Kirklees Council
Planning and Development Service
PO Box 1720
Huddersfield
HD1 9EL

Date: 25-Oct-2024
Our Ref: 2024/90237

**Discharge of conditions 3 (construction environmental management plan), 4 (public right of way), 5 (retaining walls), 6 (Phase II Report), 7 (Remediation Strategy), 9 (Remediation Validation Report) and 18 (Japanese Knotweed) of previous permission 2021/92062 for erection of 9 dwellings and associated works adjacent, Britannia Road, Golcar, Huddersfield, HD3 4QB
Application Number: 2024/90237**

PLANNING	
Project/Client:	Project No:
Residential Development	23-035
Land at Britannia Road	Dwg No:
Golcar, HD3 4QB	102
	Rev:
Drawing:	Scale:
Boundary Treatment Details	A.S. @A1
	Drawn By: Date:
	RJ 02/01/24
	Checked By: Date:
	SC

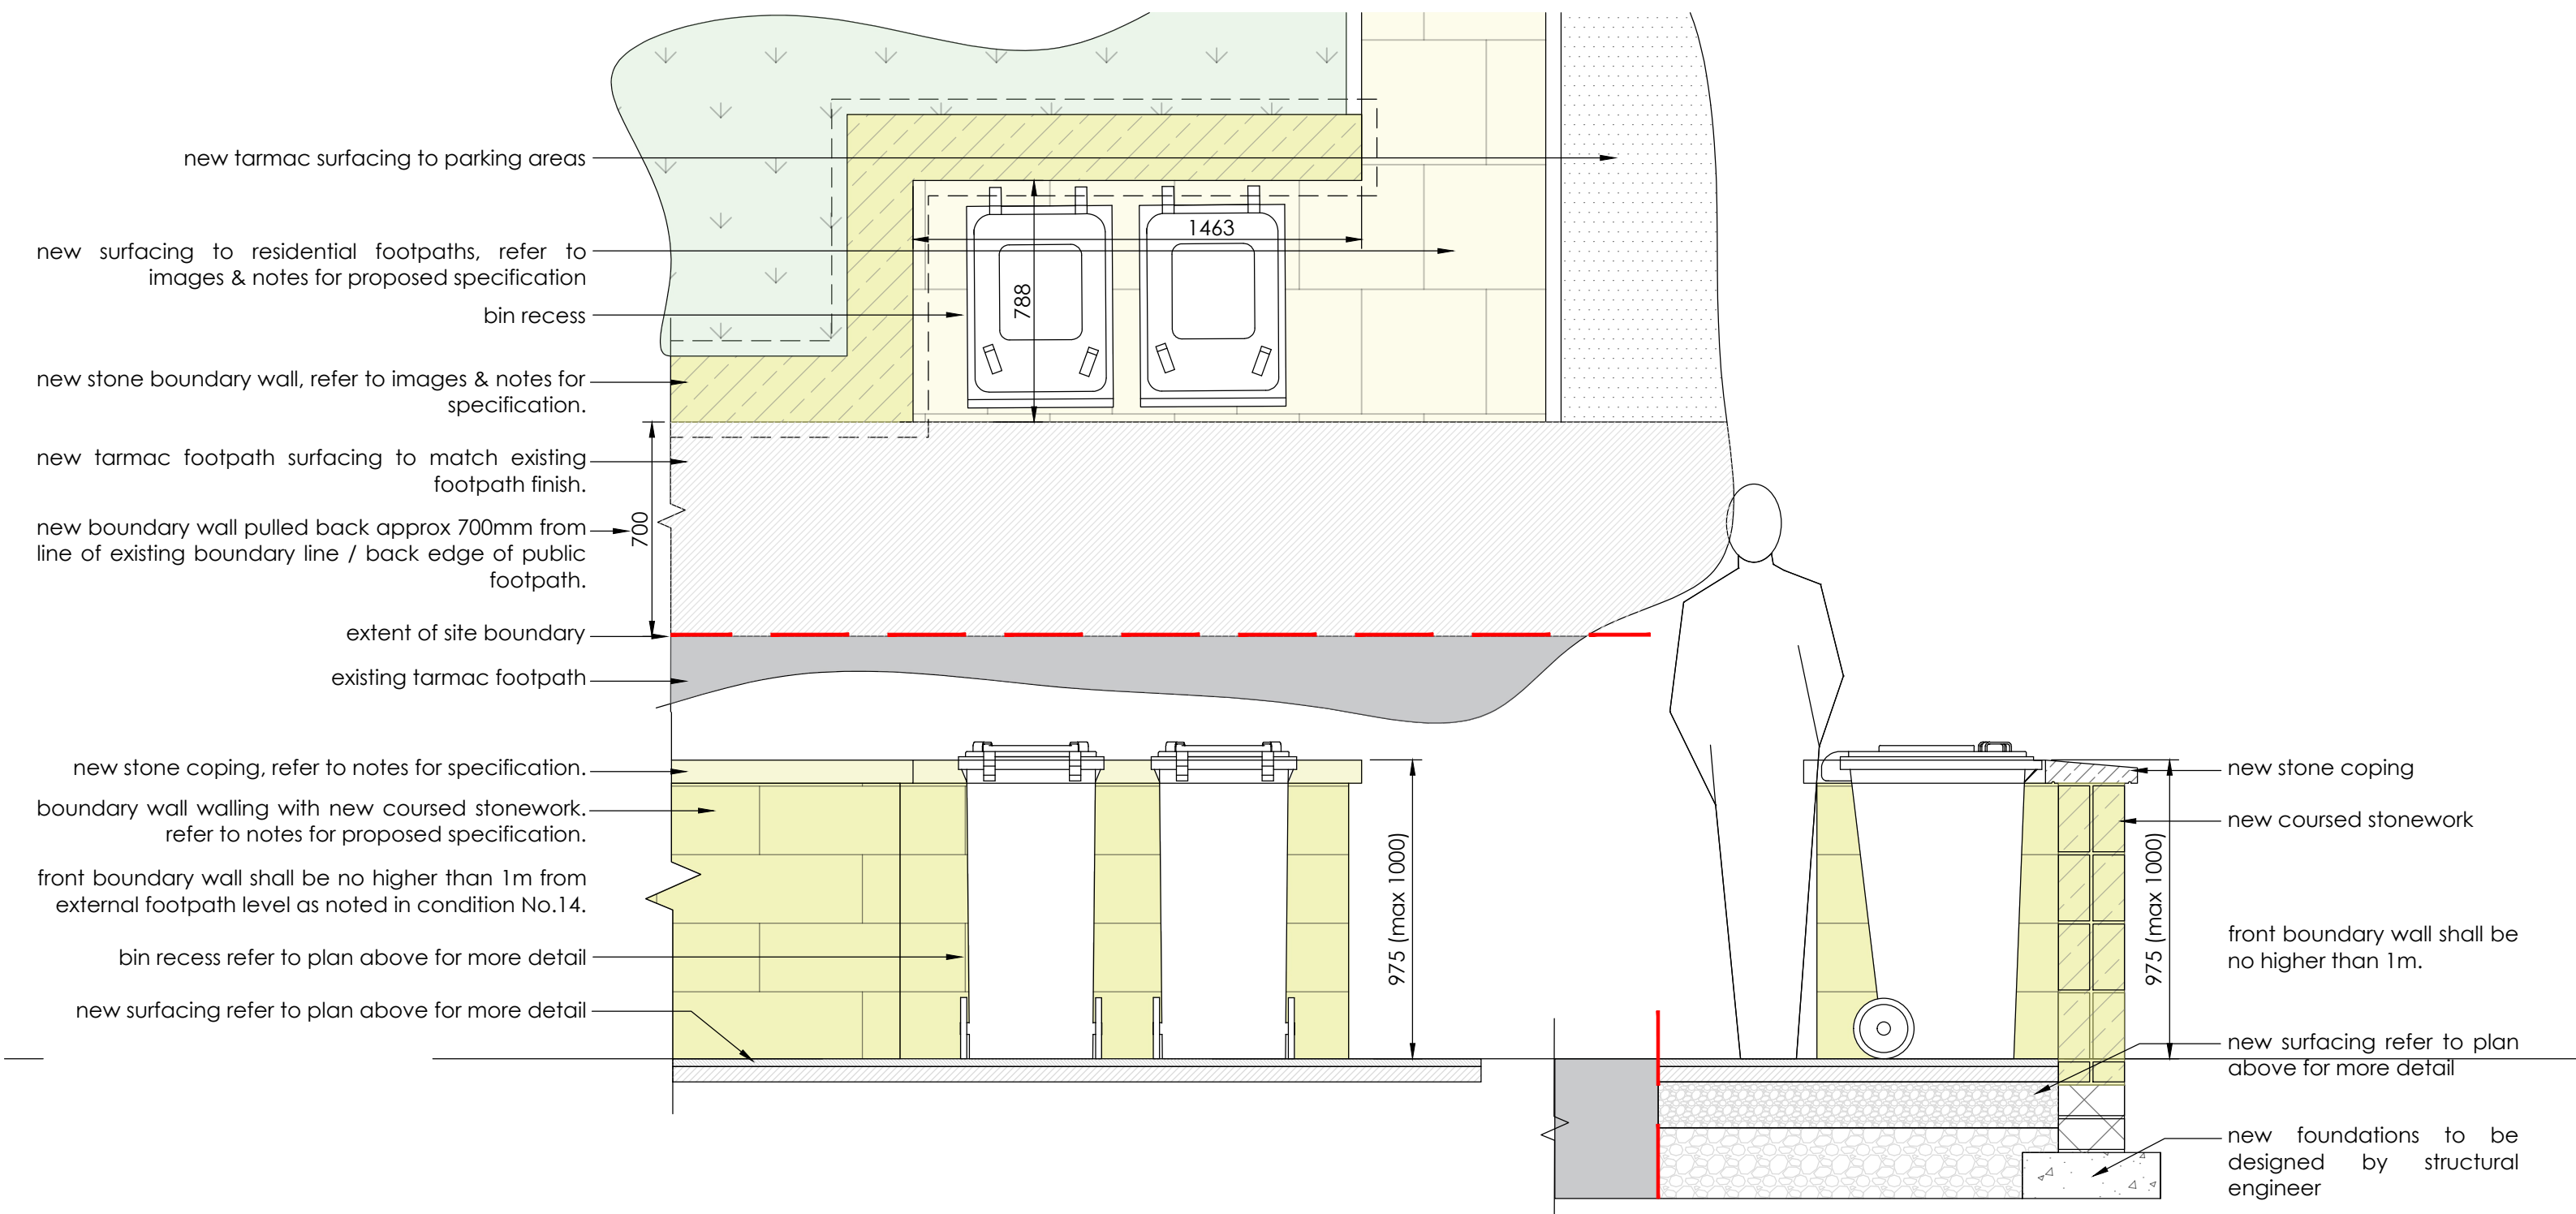
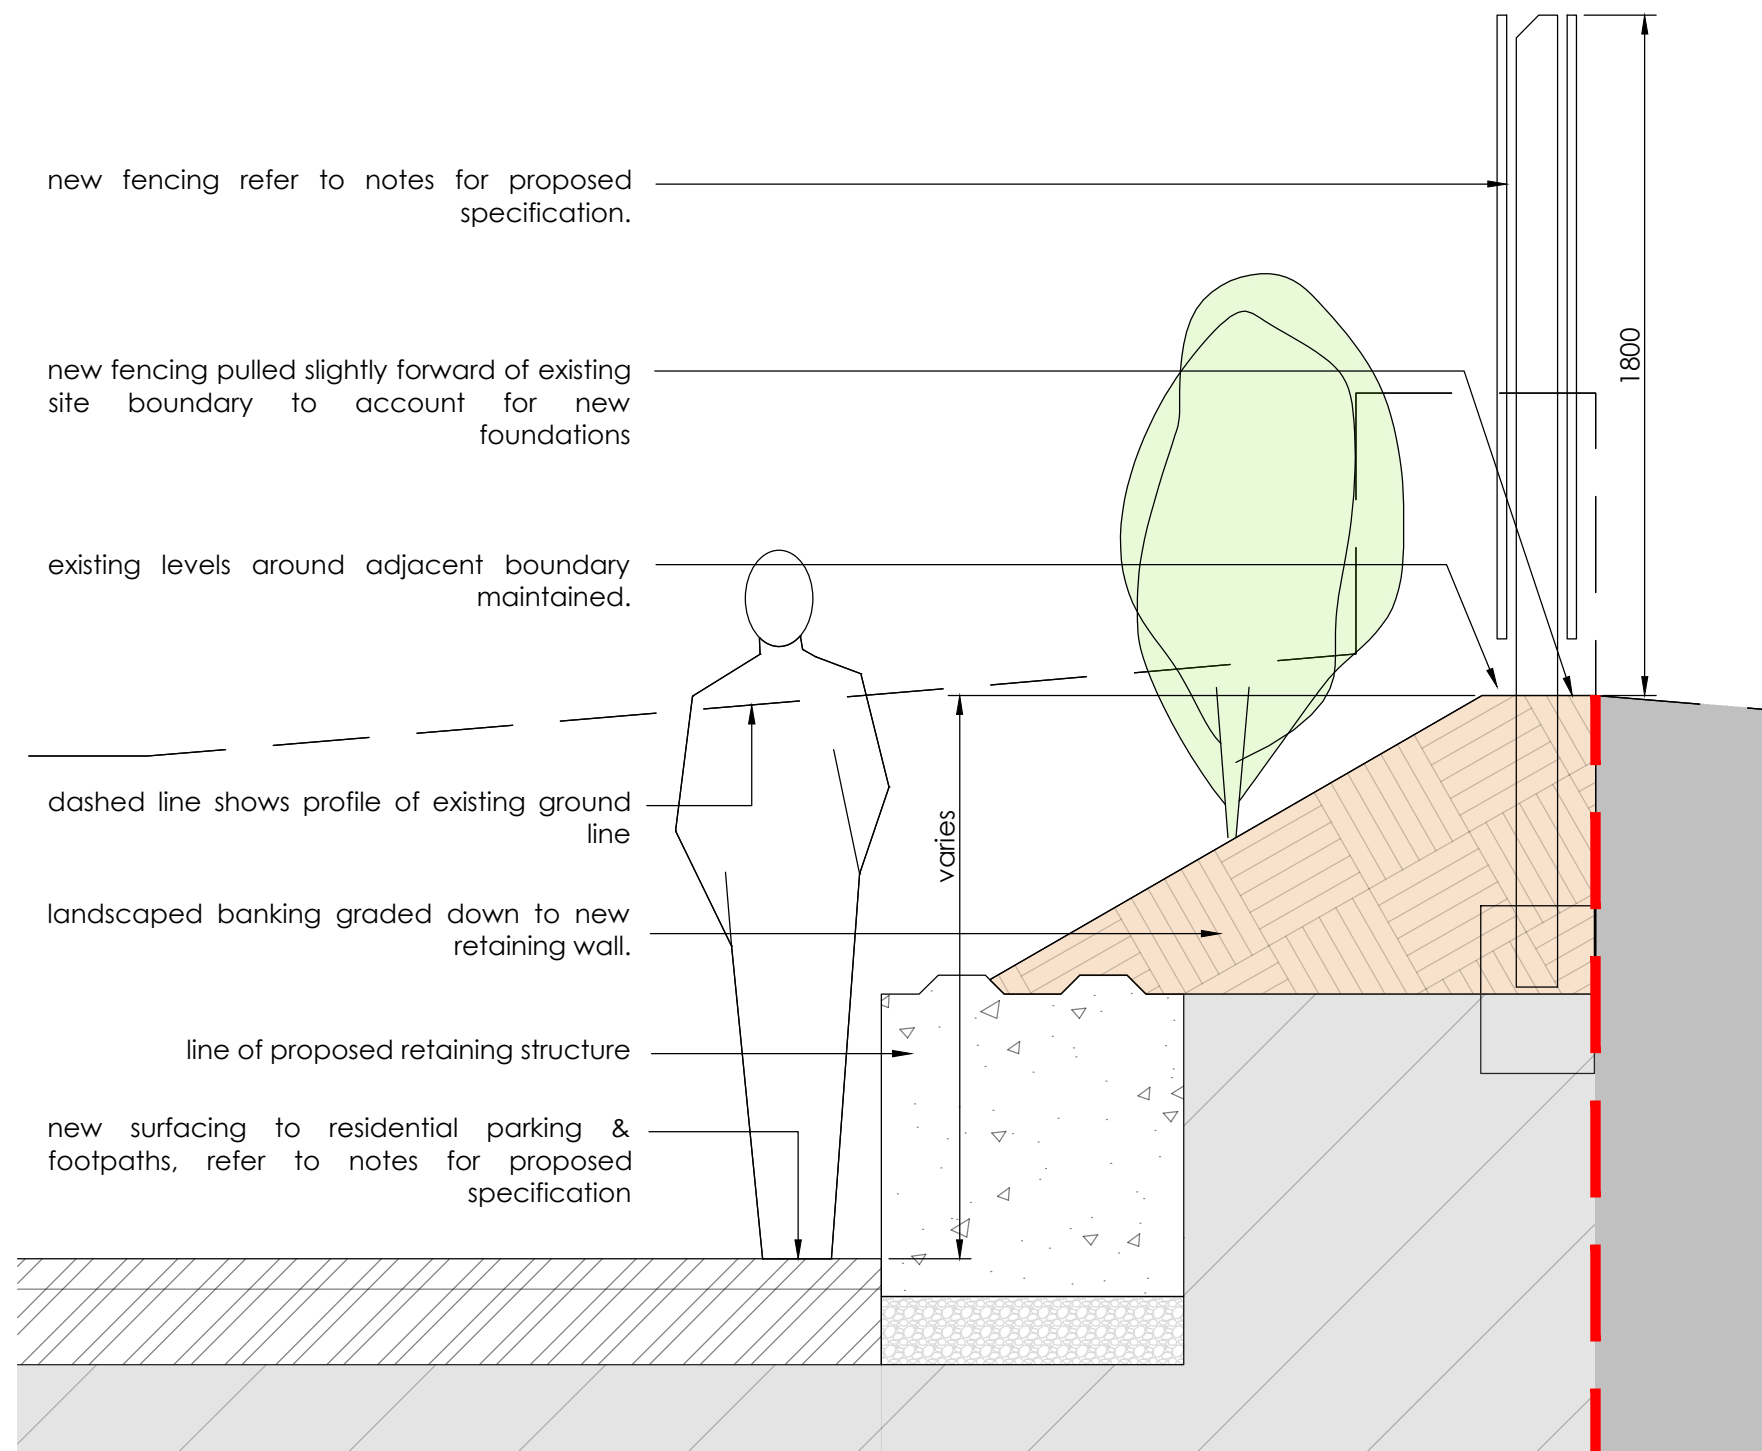
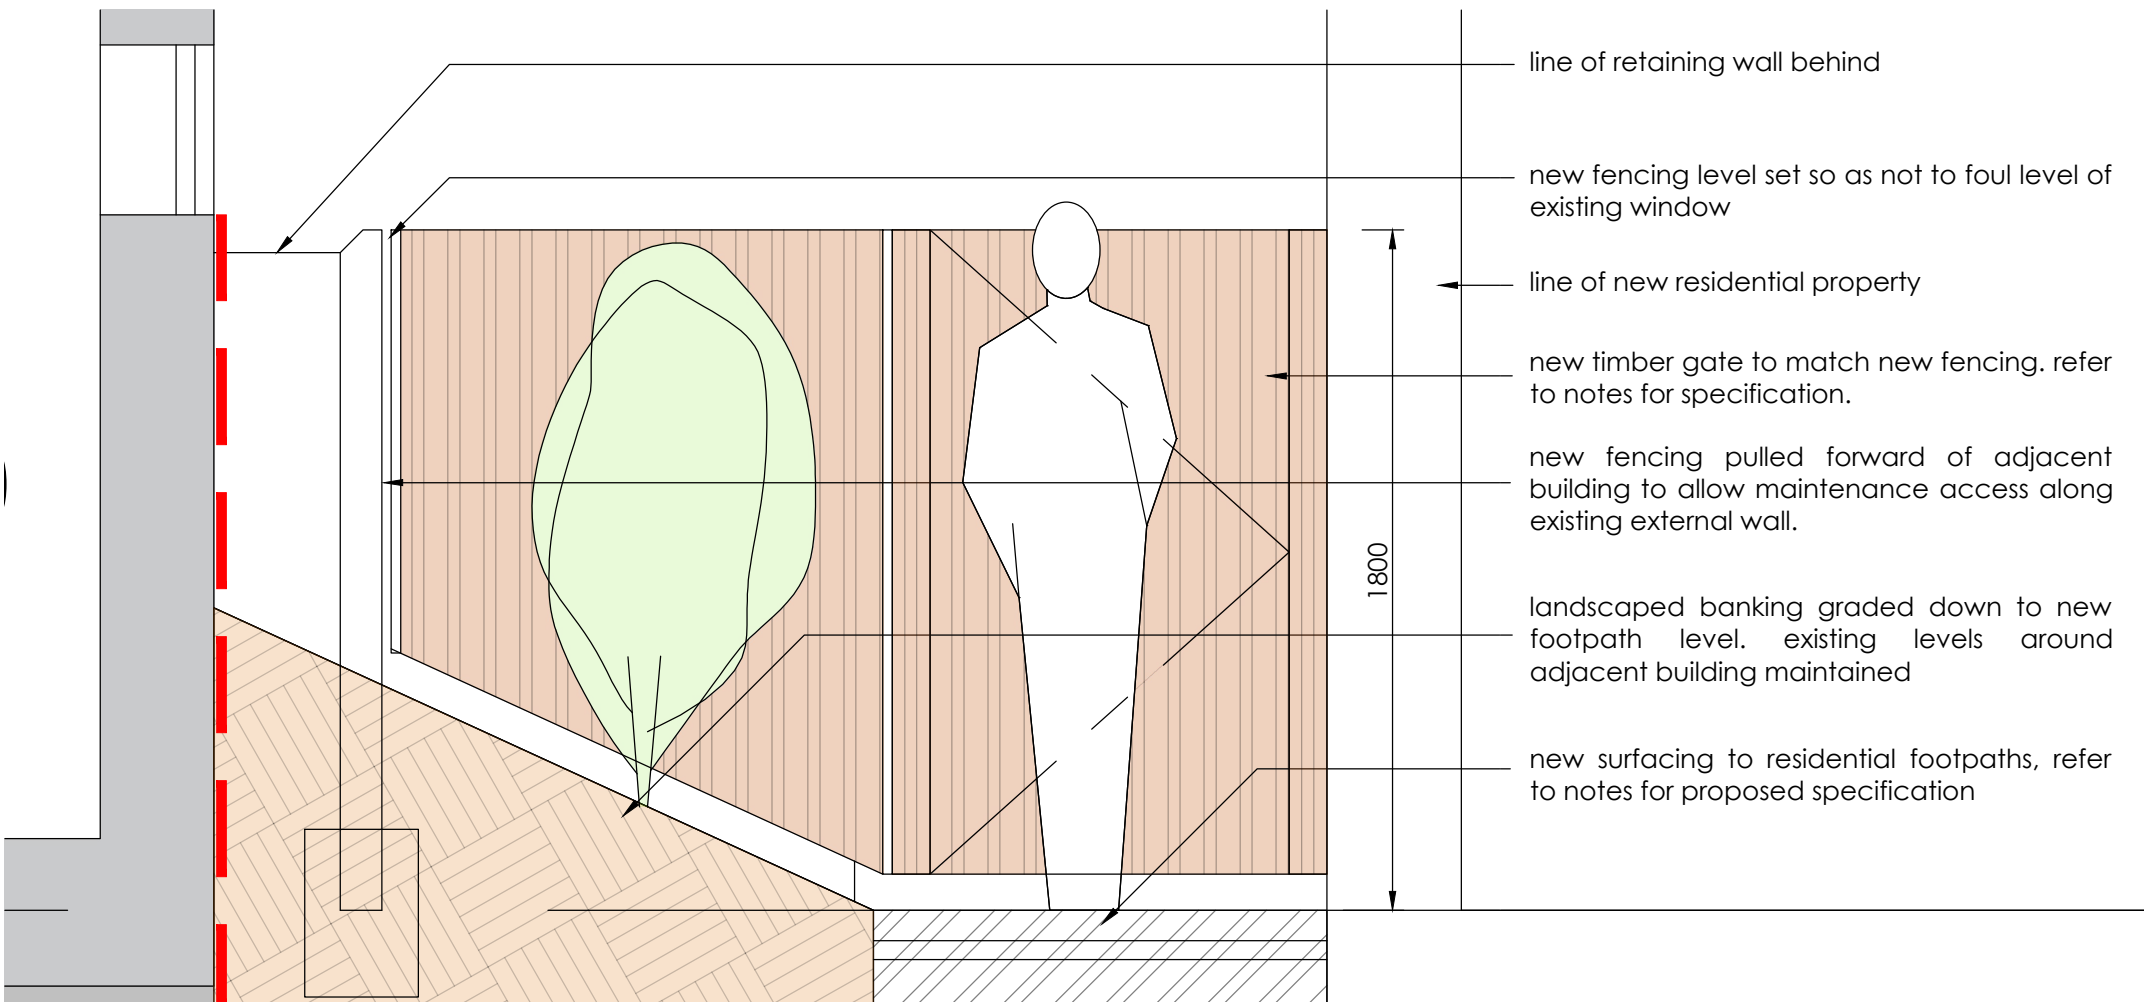
This condition requires technical and fully dimensioned sectional plans to detail the proposed engineering and retaining works, at or near the new and existing highway, to allow officers to assess that the works would be undertaken safely and without prejudicing the road network. No such adequate details have been provided.

Further to the above, the plans which have been provided indicate changes to the proposed design and method of retention / engineering works within the site from the approved plans. It is outside the scope of the Discharge of Condition process to make such amendments to the approved plans.

For the avoidance of doubt, no approval is hereby issued pursuant to condition 5.
